APPENDIX D RECOMMENDED CHANGES TO CONDITIONS

- A13. Prior to the lodgement of the first Future Development Application, the Applicant shall revise the Sydney Metro Martin Place Station Precinct Consolidated Design Guidelines (dated September 2017), to the satisfaction of the Secretary, as follows:

21 June, 12:30 PM AEST

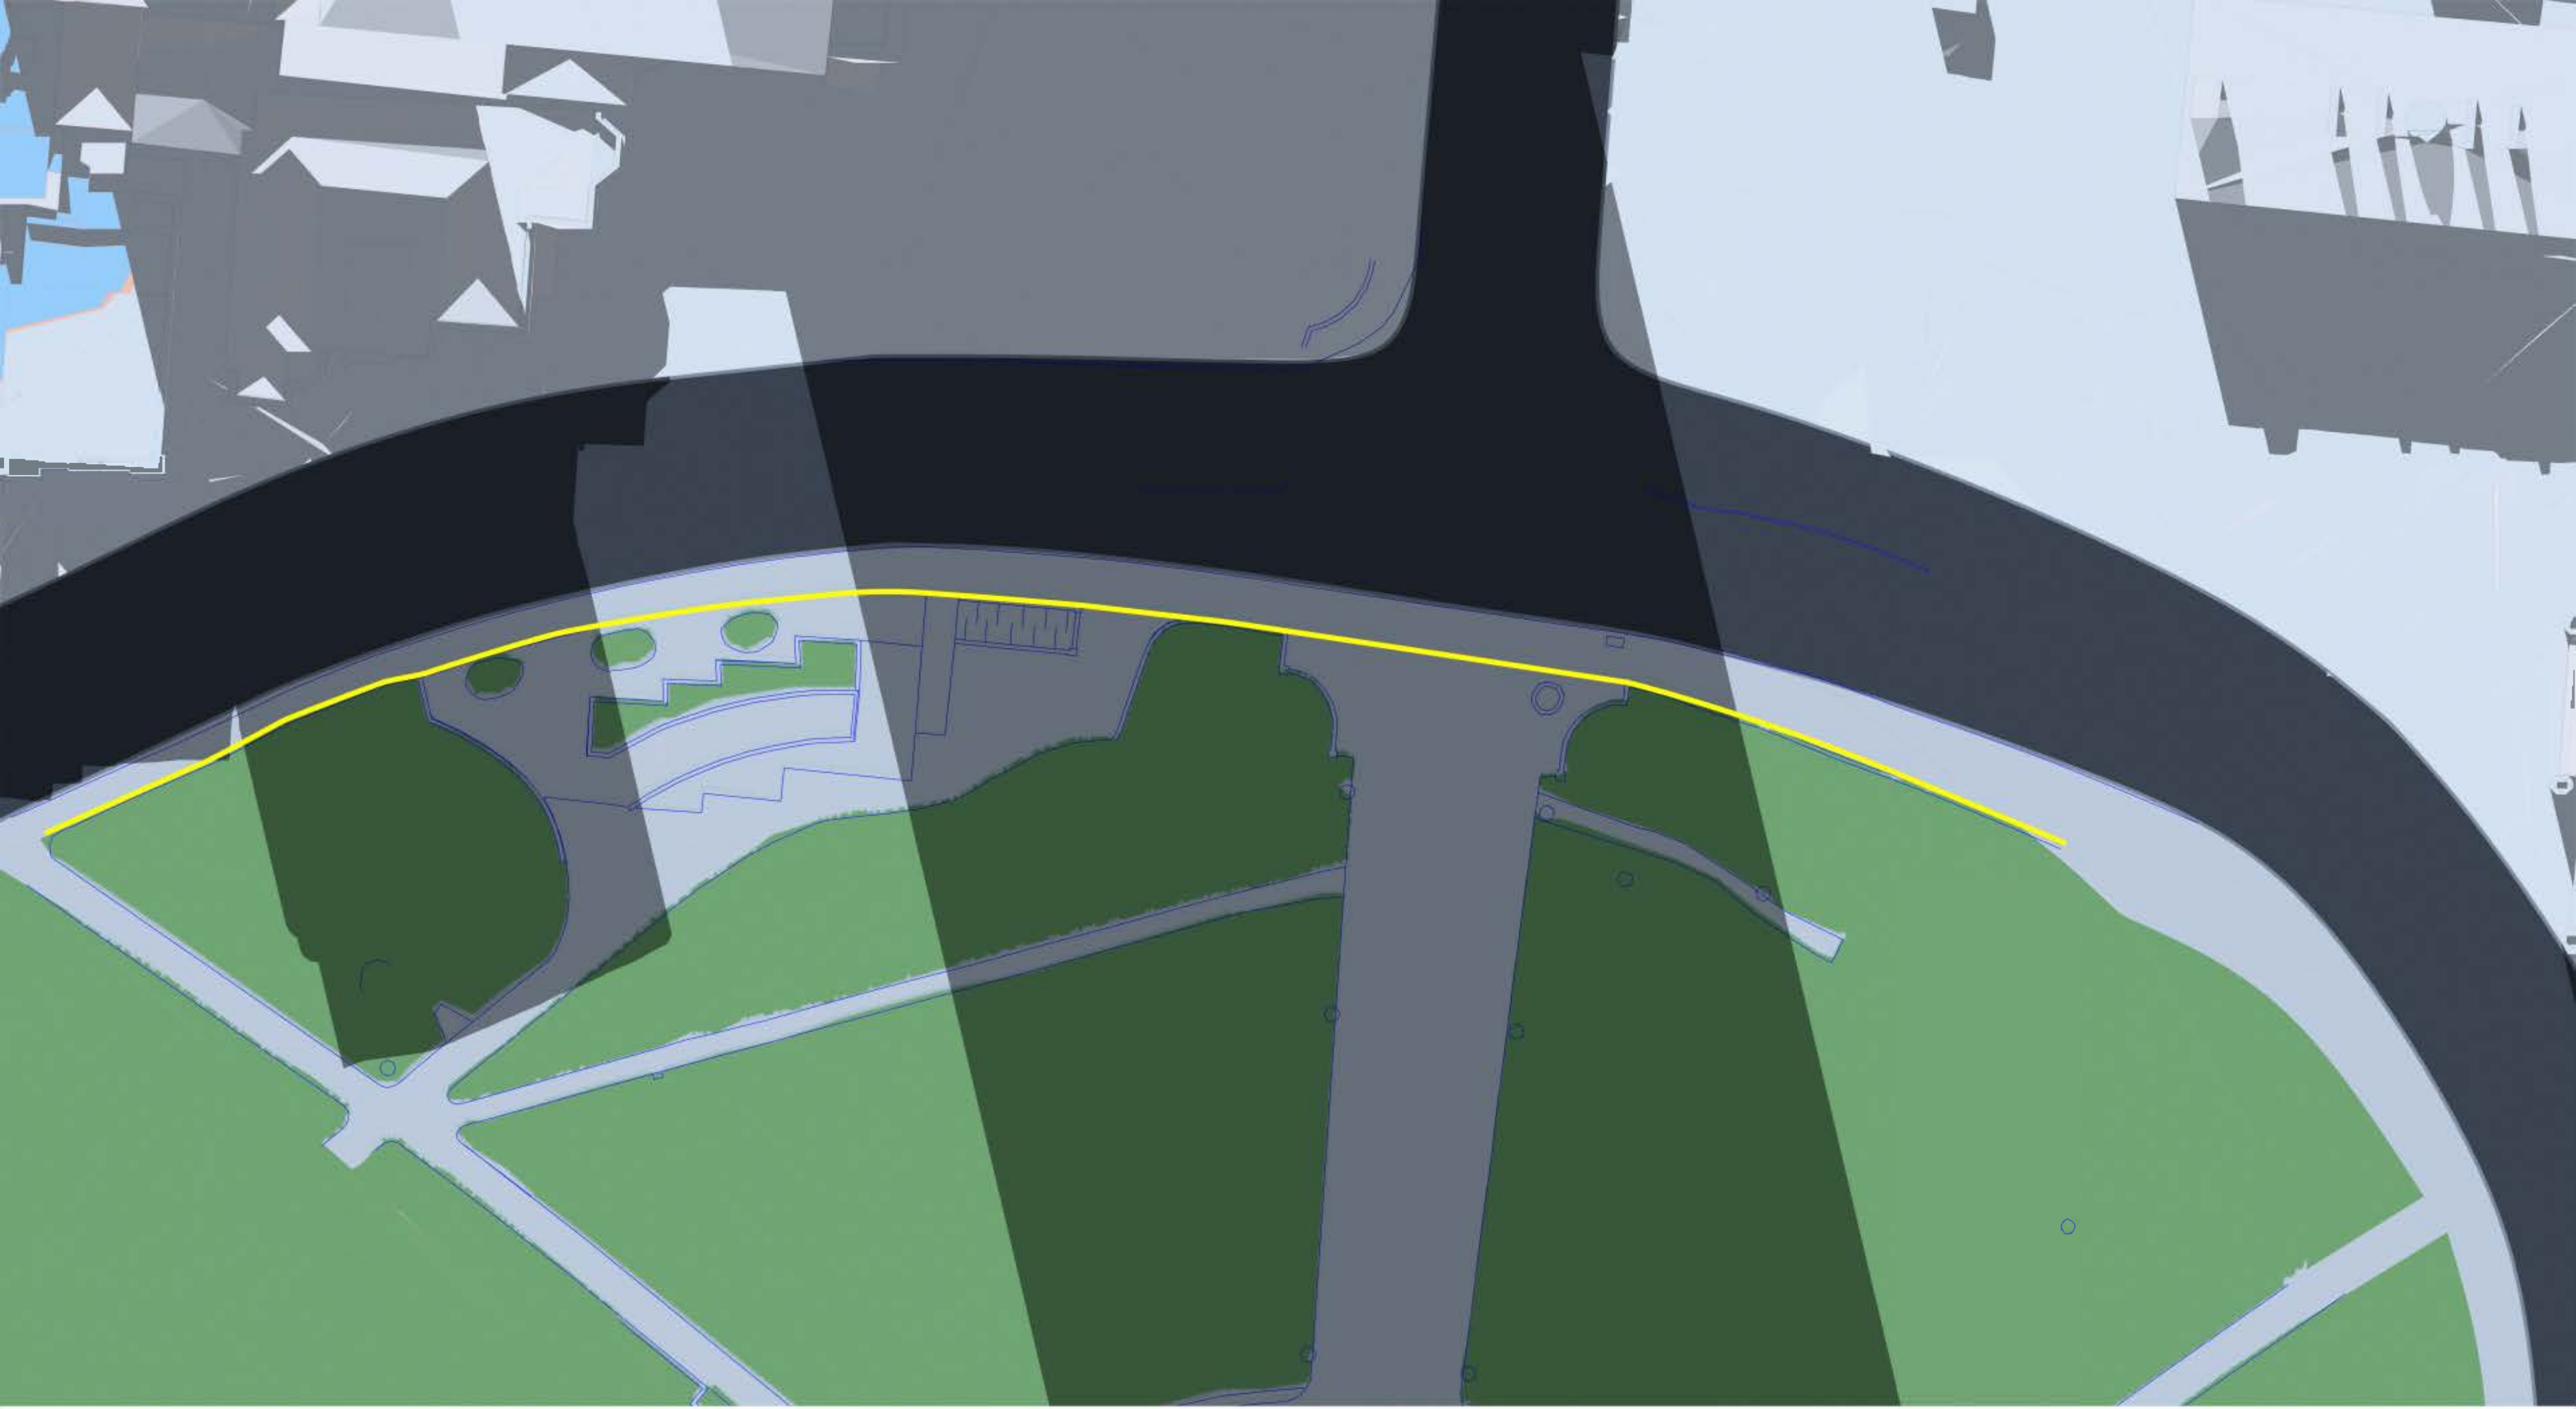
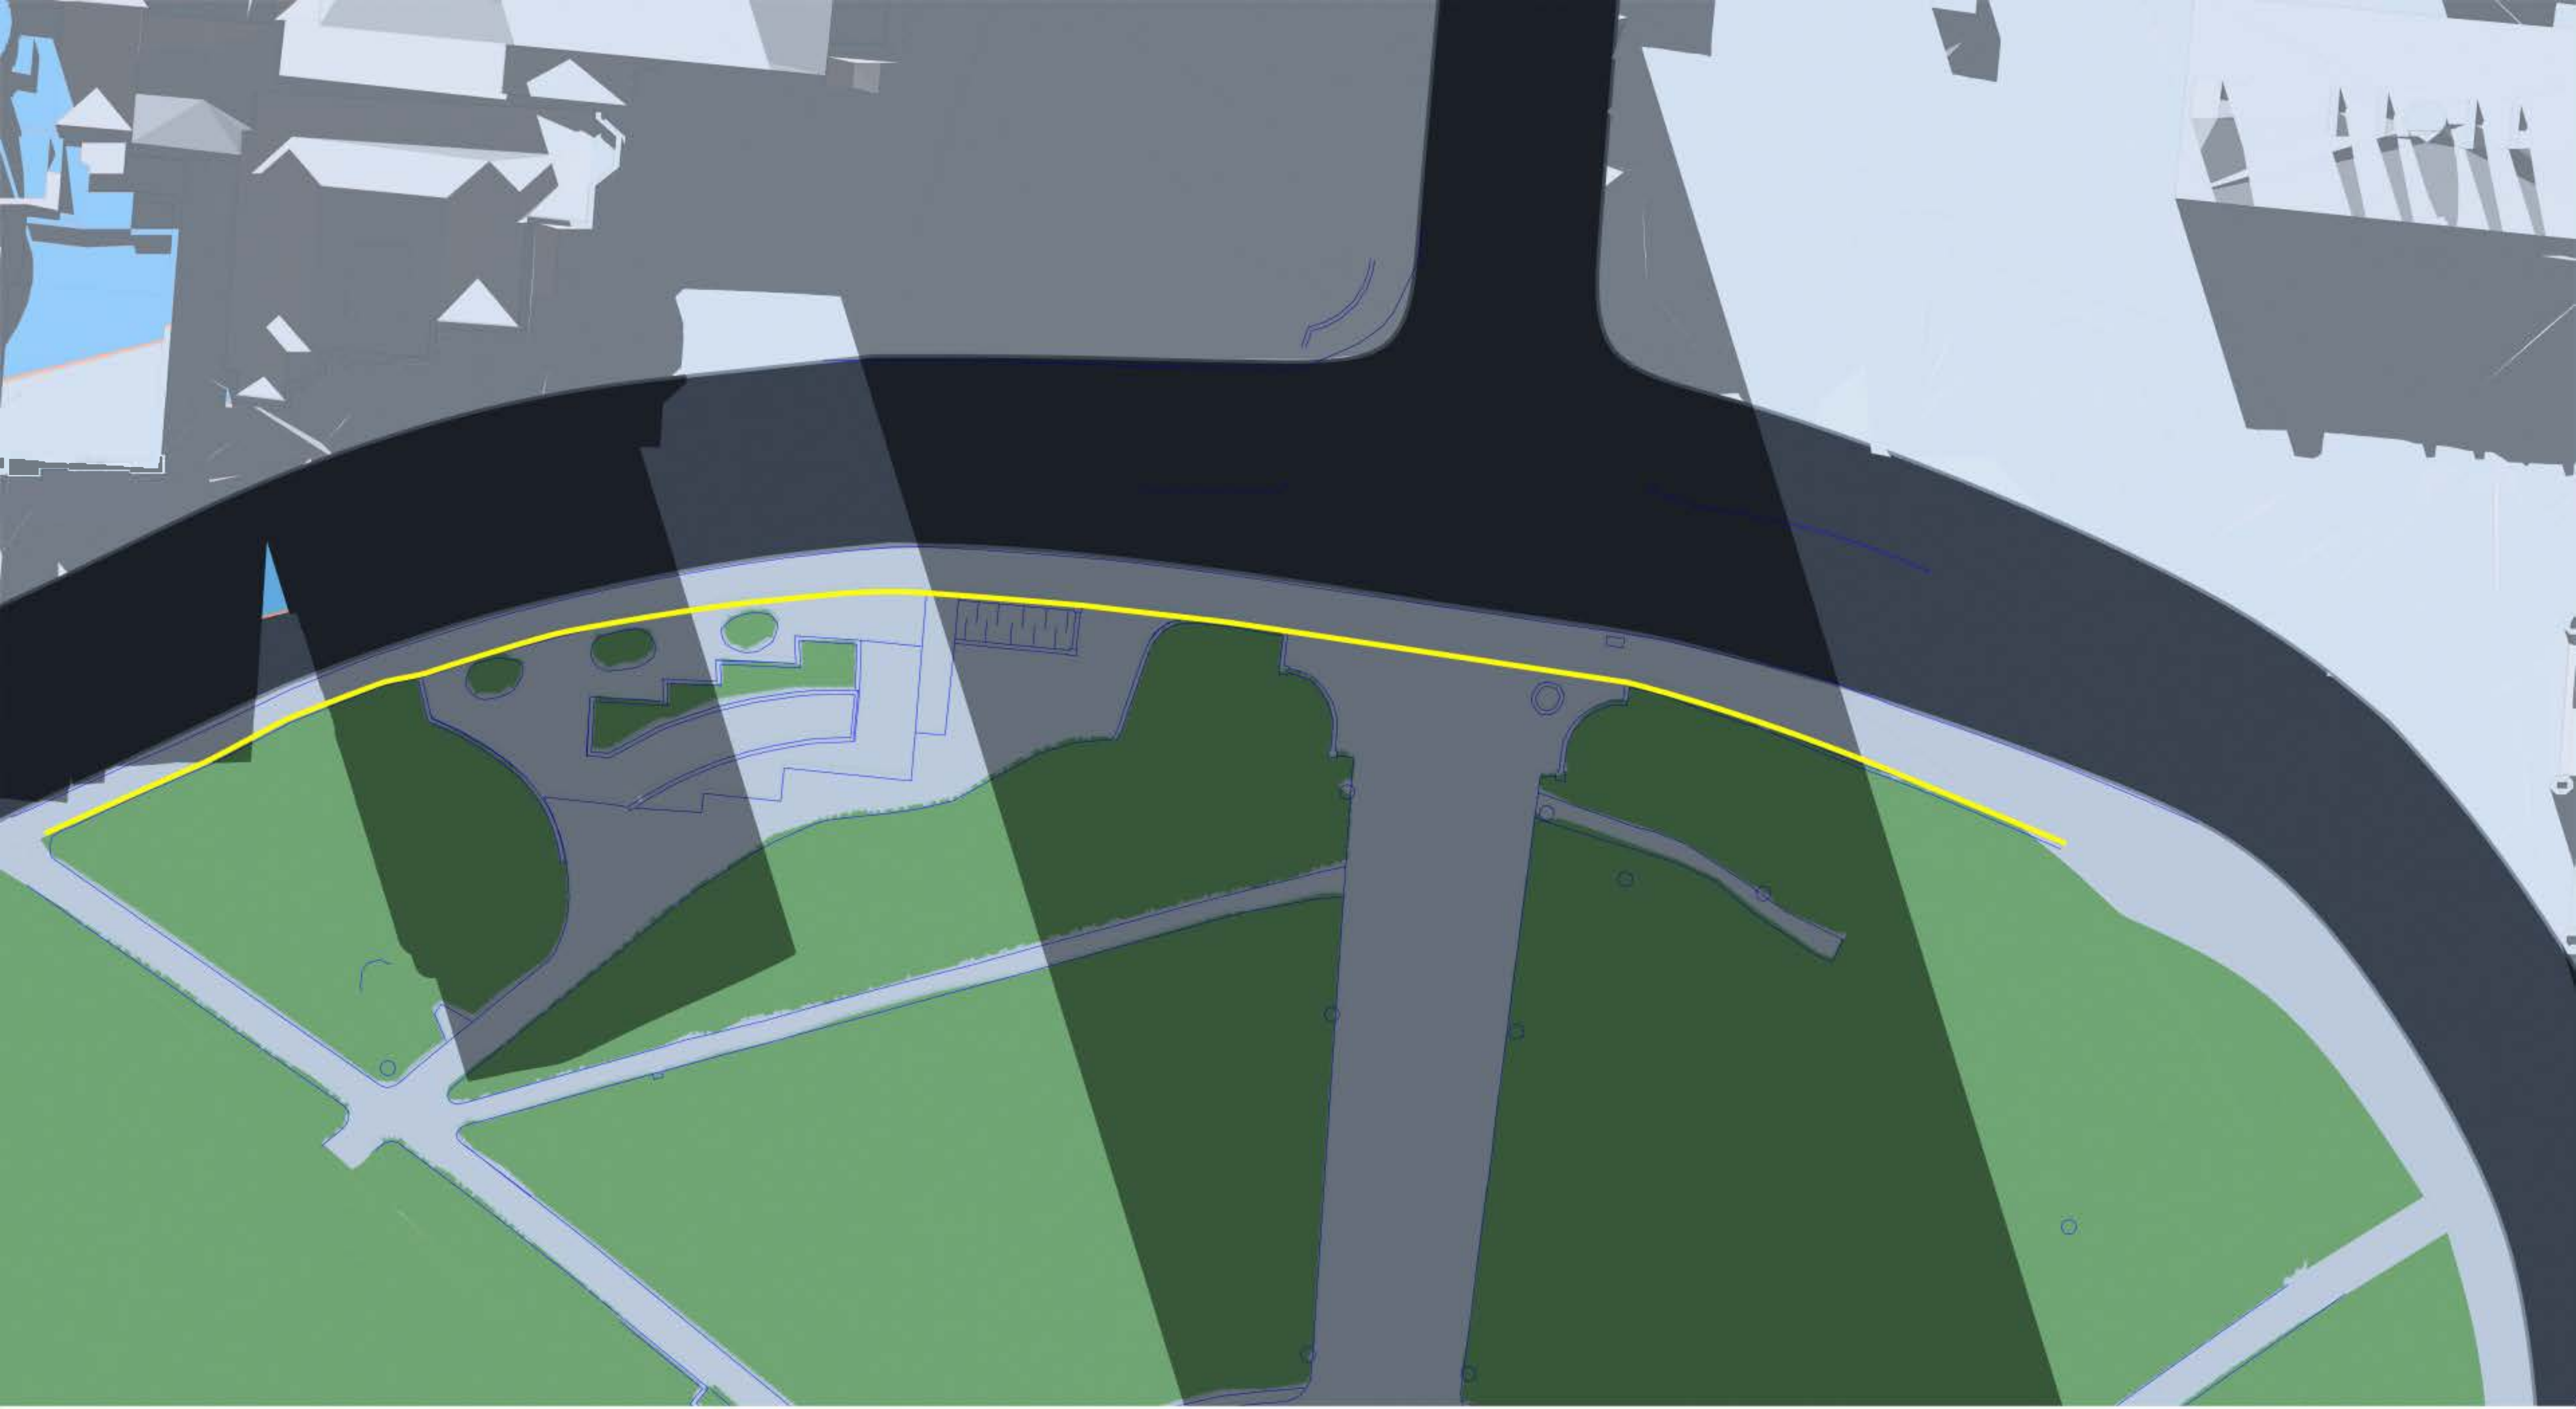
- b. In 2.2 (Public Domain): Add new **Guideline 3: Buildings on the North and South Sites shall:**
 - not result in additional overshadowing of Hyde Park between the hours of 12 and 2 pm at mid-winter (21 June), when compared to the shadow cast by existing buildings, approved buildings and the DCP/LEP compliant envelope set out in Appendix C of the Response to Submissions, titled SSDA Addendum Shadow Analysis, prepared by Grimshaw and Johnson Pilton Walker, dated August 2017
